**Nationally Significant Infrastructure Project: EN01027 Mallard Pass Solar Farm**

**Response to Rule 17 Request for Further Information – October 2023**

Lincolnshire County Councils (“LCC”) response to the ExAs Rule 17 Request for Further Information (letter dated 18 October 2023) is set out below.

Figure 1 - 0.5% AEP Extents

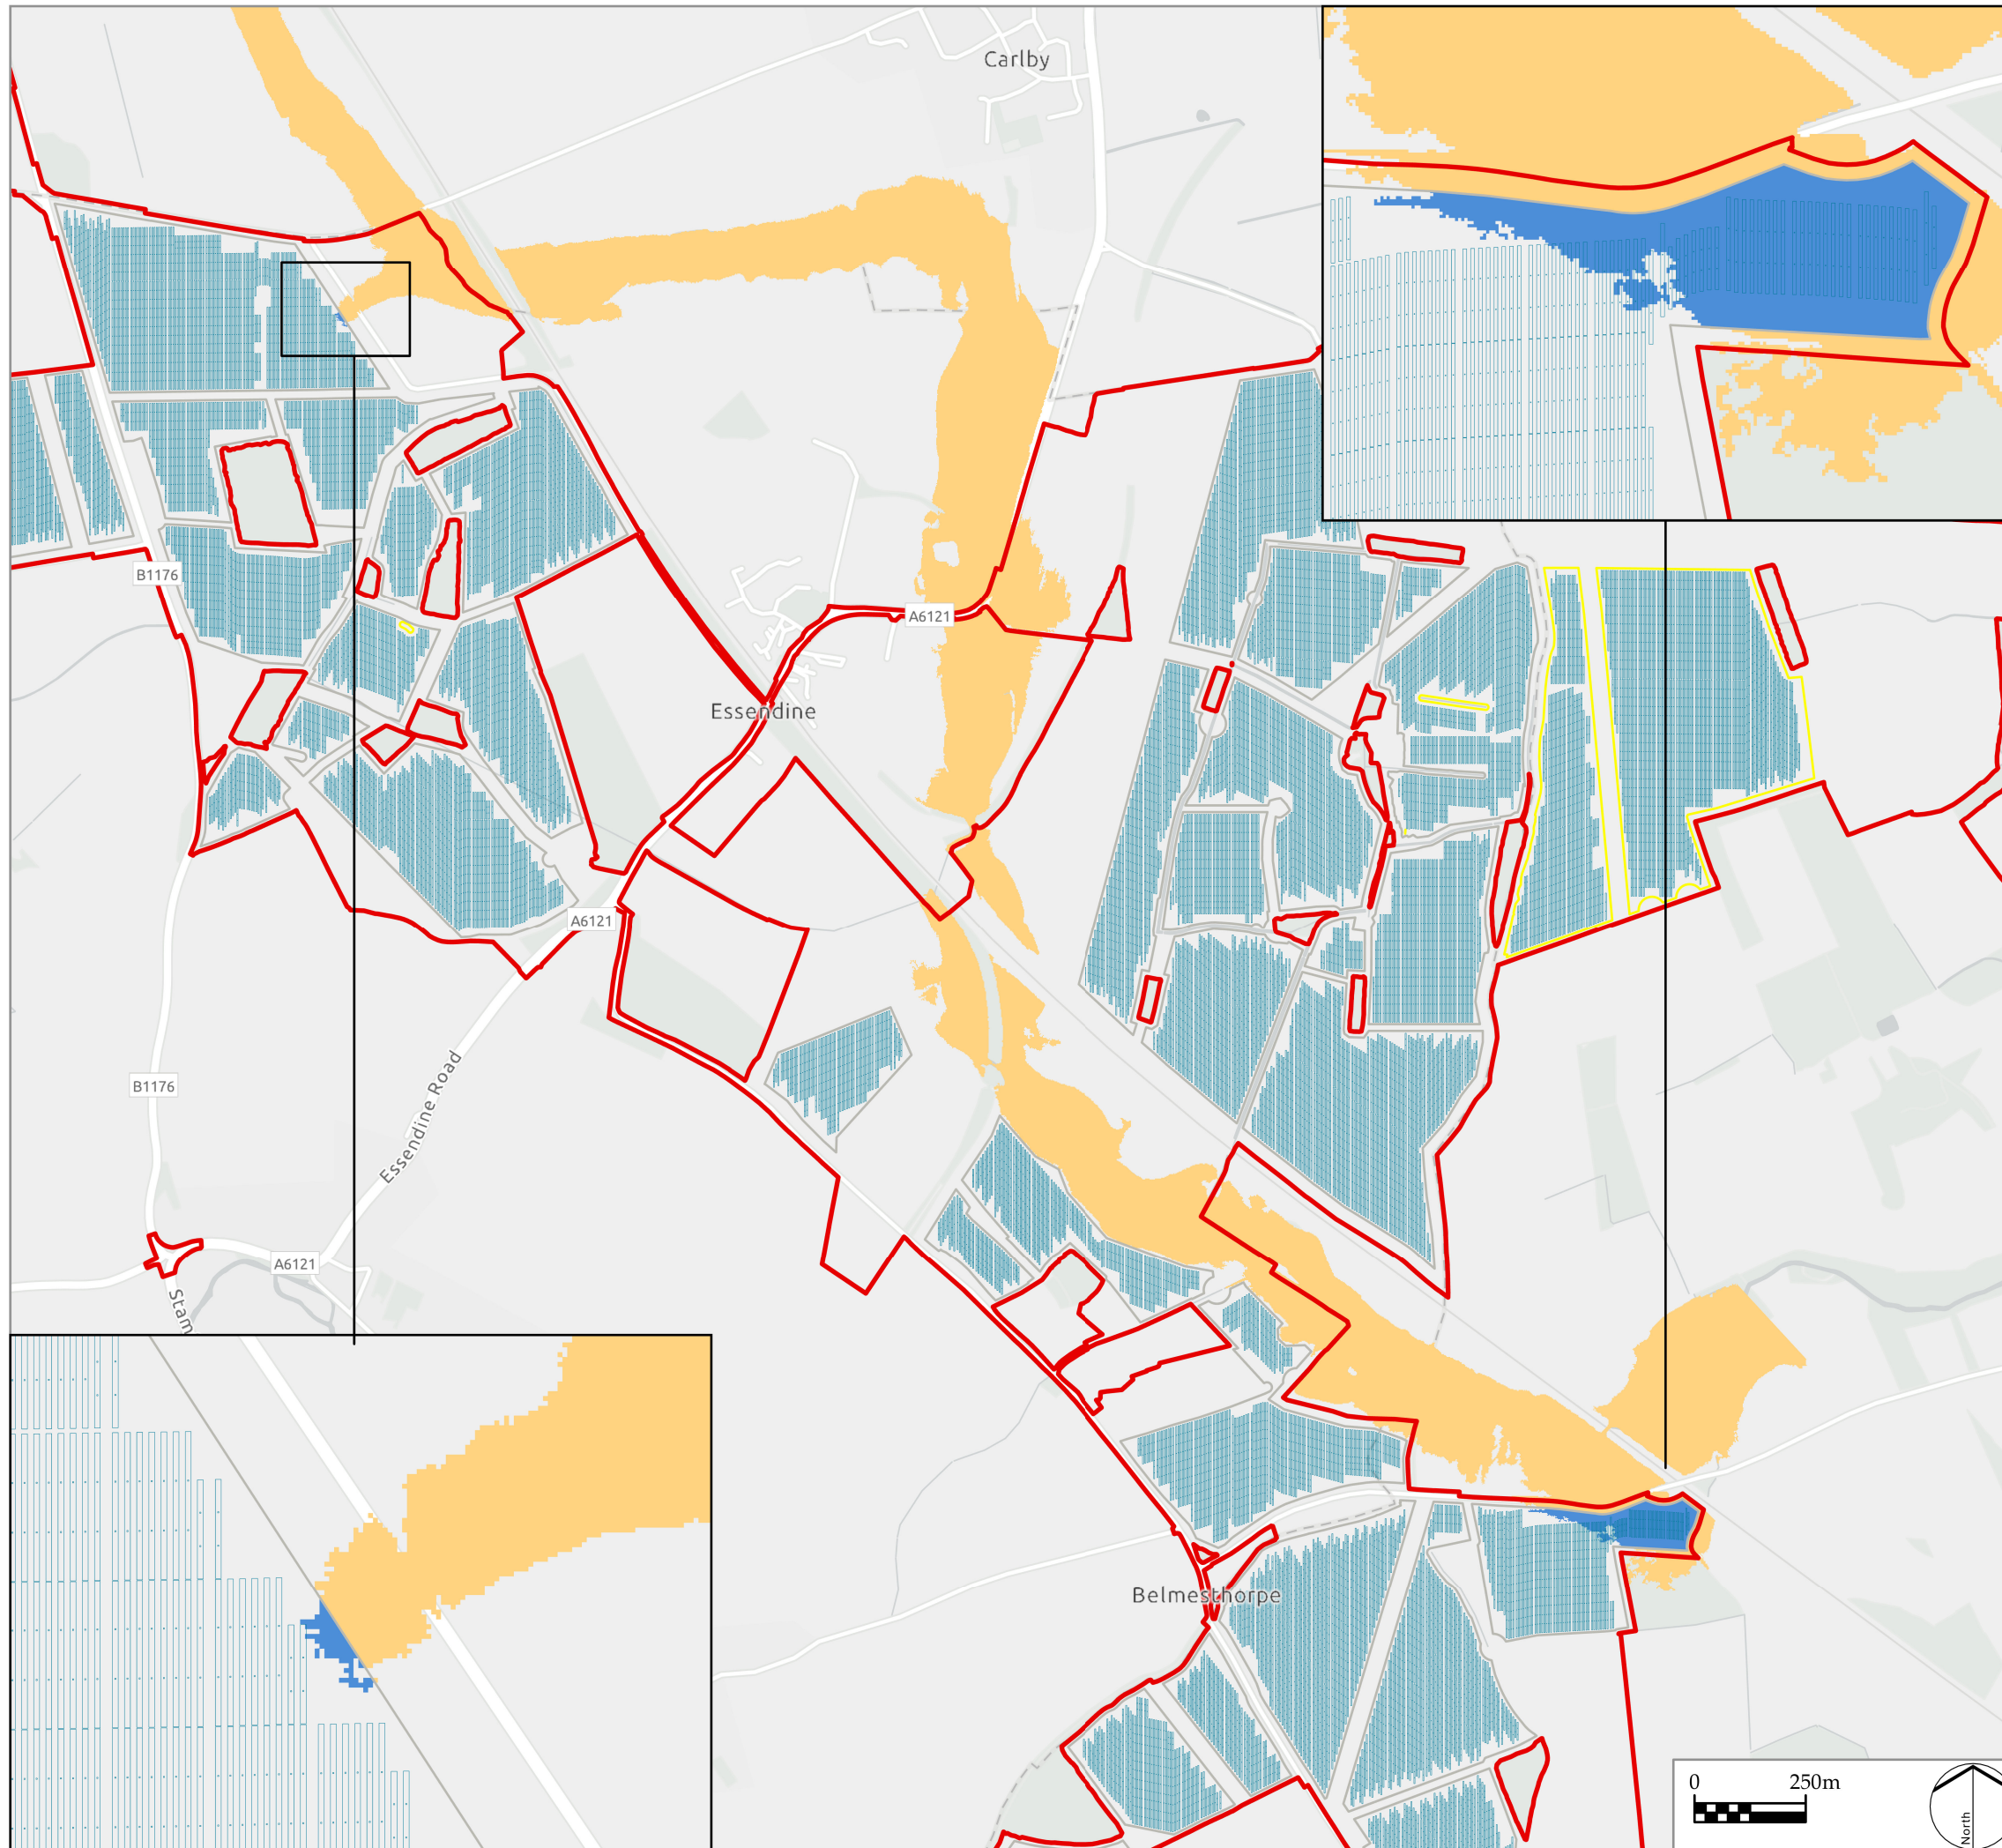
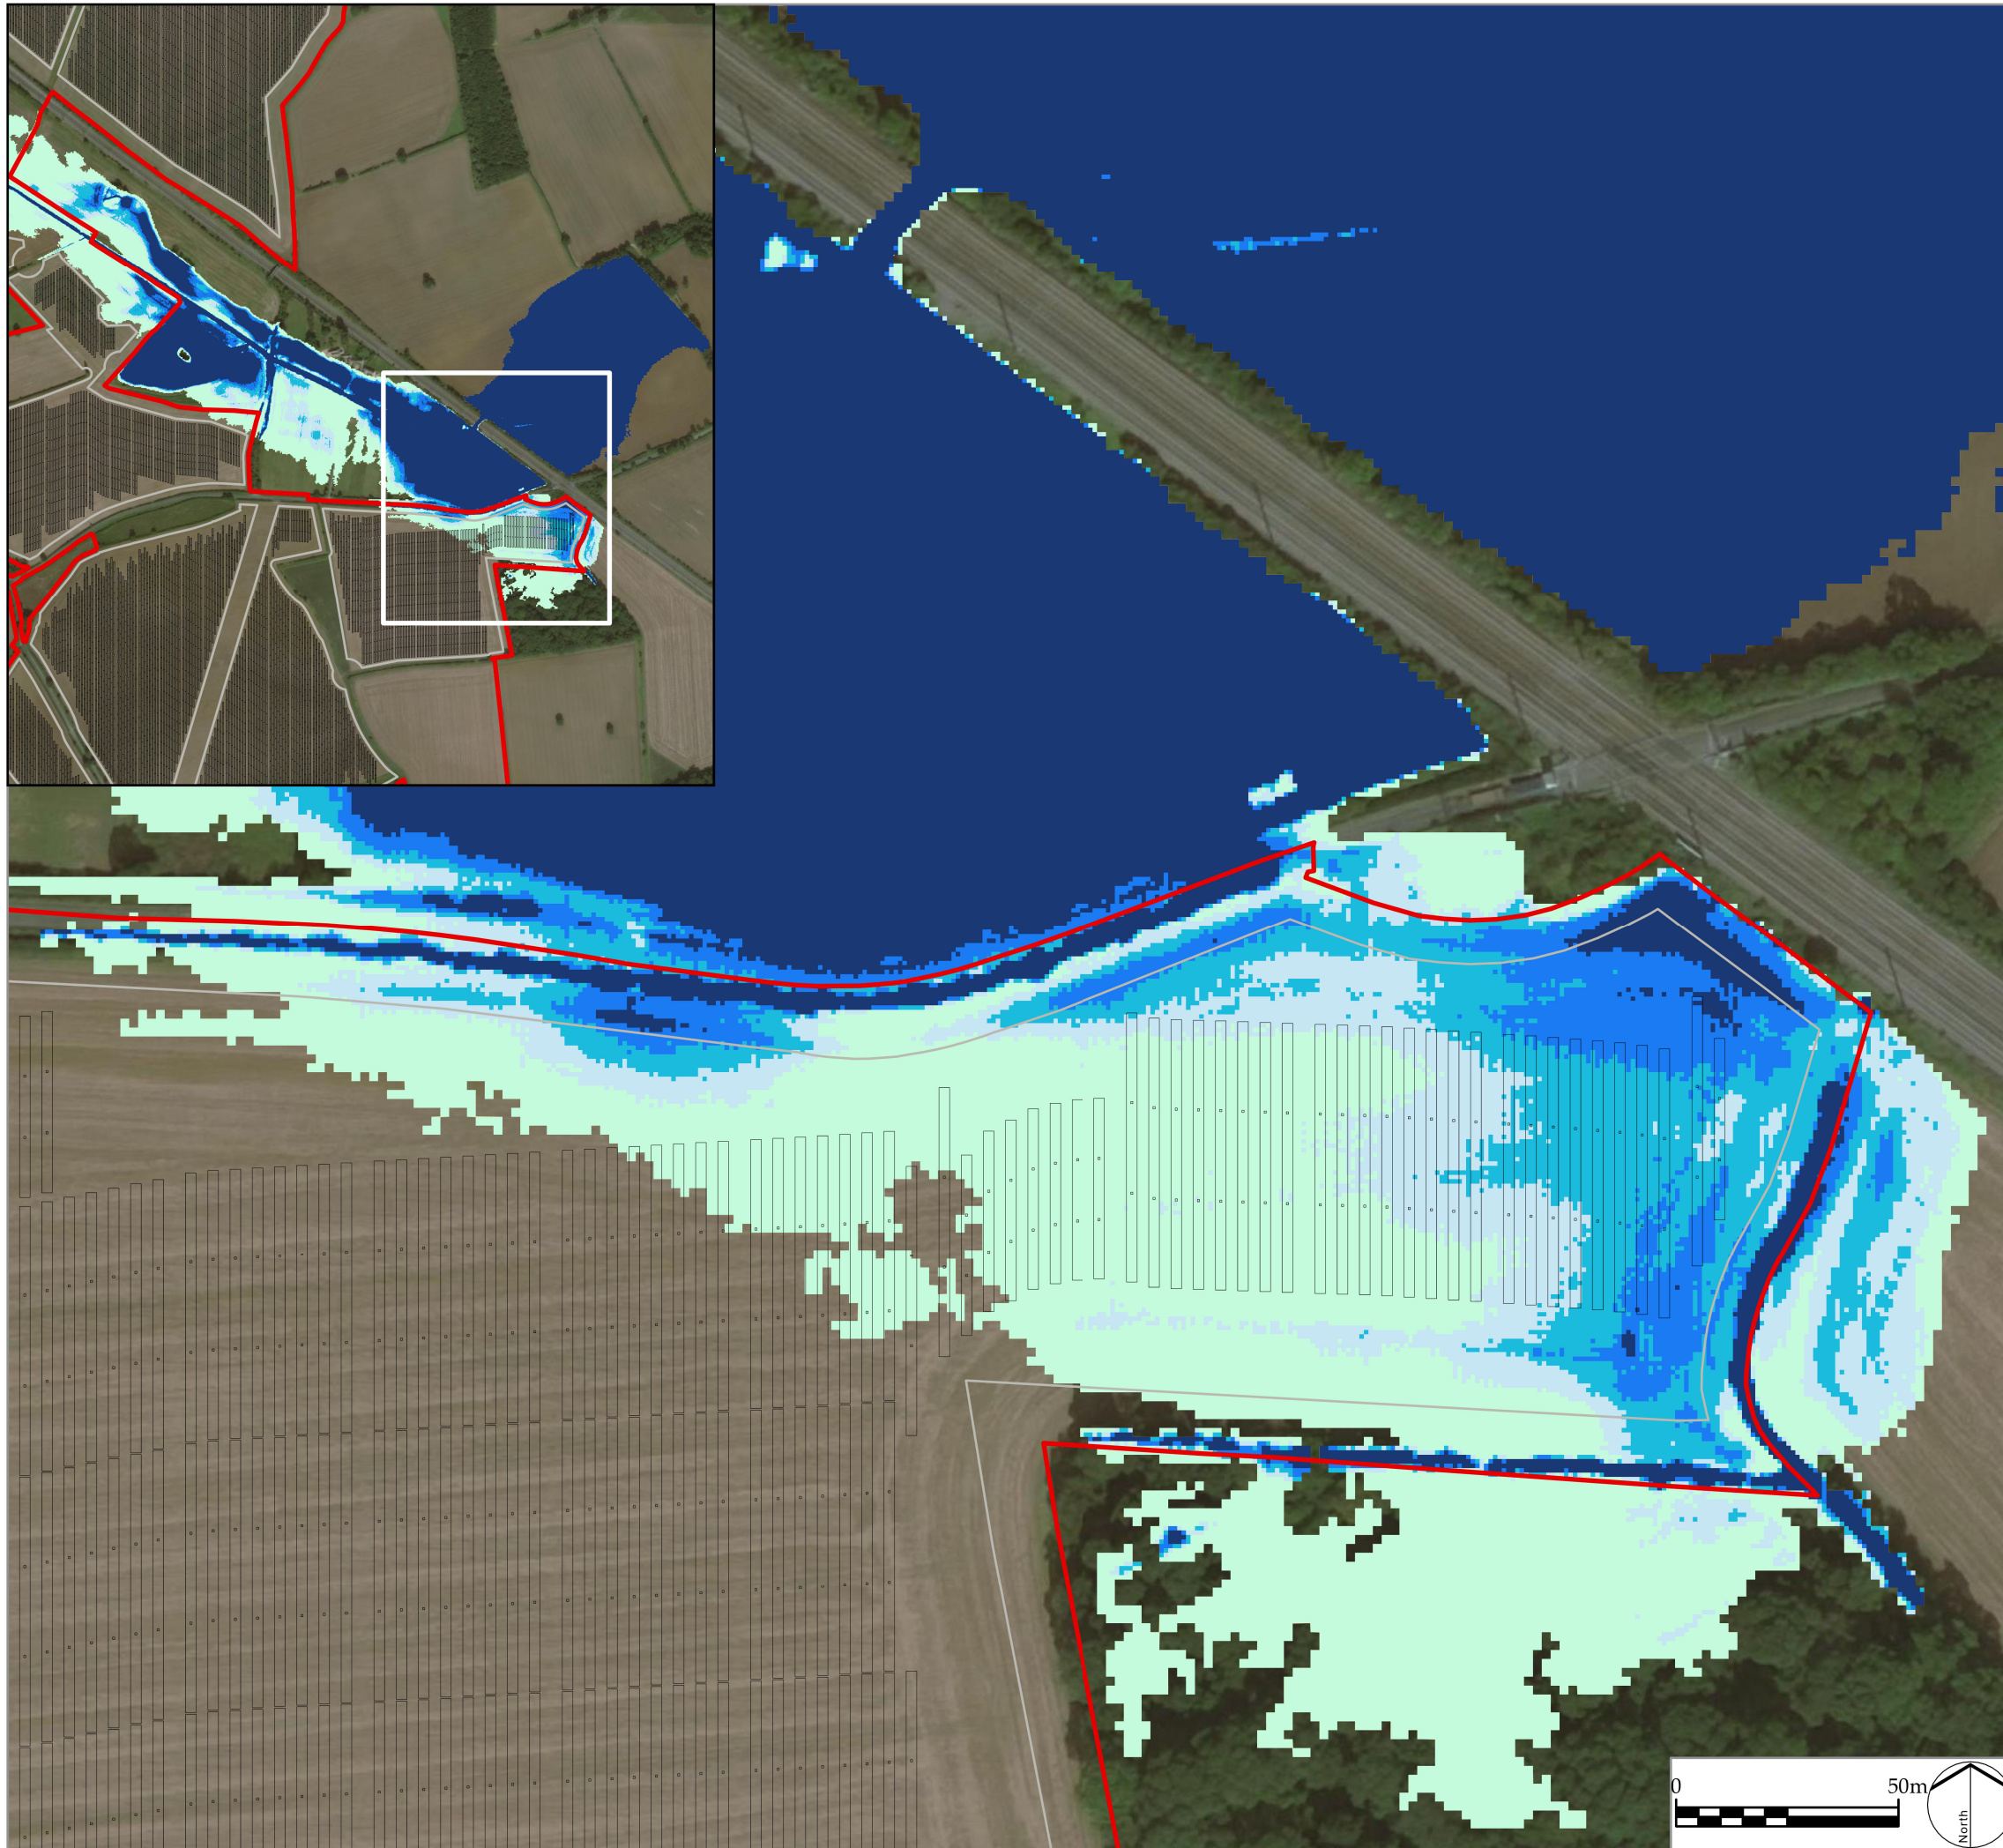
<p><b>Water and Flood Risk</b> In response to discussion at ISH4 regarding the implications of the proposed 60 year operational time limit for the Flood Risk Assessment in the 2080s, the Applicant provided further assessment of this issue in its Statement on 60 Year Time Limit at Deadline 7 [REP7-038]. This followed liaison with the Environment Agency on the approach to further modelling. The Environment Agency also committed to review the analysis and results when available [REP7-051]. The subsequent proxy modelling undertaken indicates that</p>

4.1ha of the PV array area could be submerged under the leading PV array edge. If this modelling continues to be the case in 2078 when further consideration is proposed, the Applicant concludes that this could be mitigated by changing the pitch of the arrays and that mechanisms in the oOEMP would ensure that such measures are put into place. However, the latest version of the oOEMP submitted at Deadline 7 removes provisions to address the issue with revisions to Table 3-7. As an alternative, a new Requirement (R19) is proposed in the latest dDCO regarding long term flood risk mitigation. It is understood that this is the Environment Agency's preferred method.

<p>b) Can the Environment Agency, Lincolnshire County Council, Rutland County Council and South Kesteven District Council confirm if they agree with the Applicant's position that the conclusions of the Flood Risk Assessment and Chapter 11 of the Environmental Statement remain unchanged with the introduction of a 60 year time limit?</p>	<p>As the proxy modelling indicates parts of the PV array area could be submerged if the development persists beyond 2078, then this does clearly change the original conclusions of the Flood Risk Assessment and Chapter 11 of the ES which had concluded (based on a 40 year life) that the development would not be at risk from flooding. In order for the development to be flood compatible for the proposed 60 year lifetime, the Applicant relies upon revisions being made and agreed to the design of the development in the future rather than the development being designed to be compatible from the outset. As there is no guarantee approval for such revisions will be given then it is not valid to conclude that there are no significant effects at this stage. Therefore whilst LCC accepts there would be no significant effect for a development with a 40 year life we do cannot agree the same can be said should a development with a 60 year life.</p>

<p>c) Do Lincolnshire County Council, Rutland County Council and South Kesteven District Council have any further comments on the Applicant's updated consideration of flood risk?</p>	<p>Rather than rely upon revisions being made/approved to the development in the future, the development should demonstrate from the outset that it is capable of being safeguarded from flood risk for its lifetime. As a result, LCC maintain that should the ExA be minded to grant the DCO then this should be time-limited to 40 years which is consistent with the period originally assessed as part of the ES and which showed that the development is not at risk of flooding during this period.</p>

<p>Should the Applicant wish to retain the development beyond the 40 year limit then they could seek to extend the end-date in the future and at that time further modelling could be carried out to assess if changes are needed to the development whether that be by removing areas at risk or altering the pitch of panels to take them out of the</p>
--	--
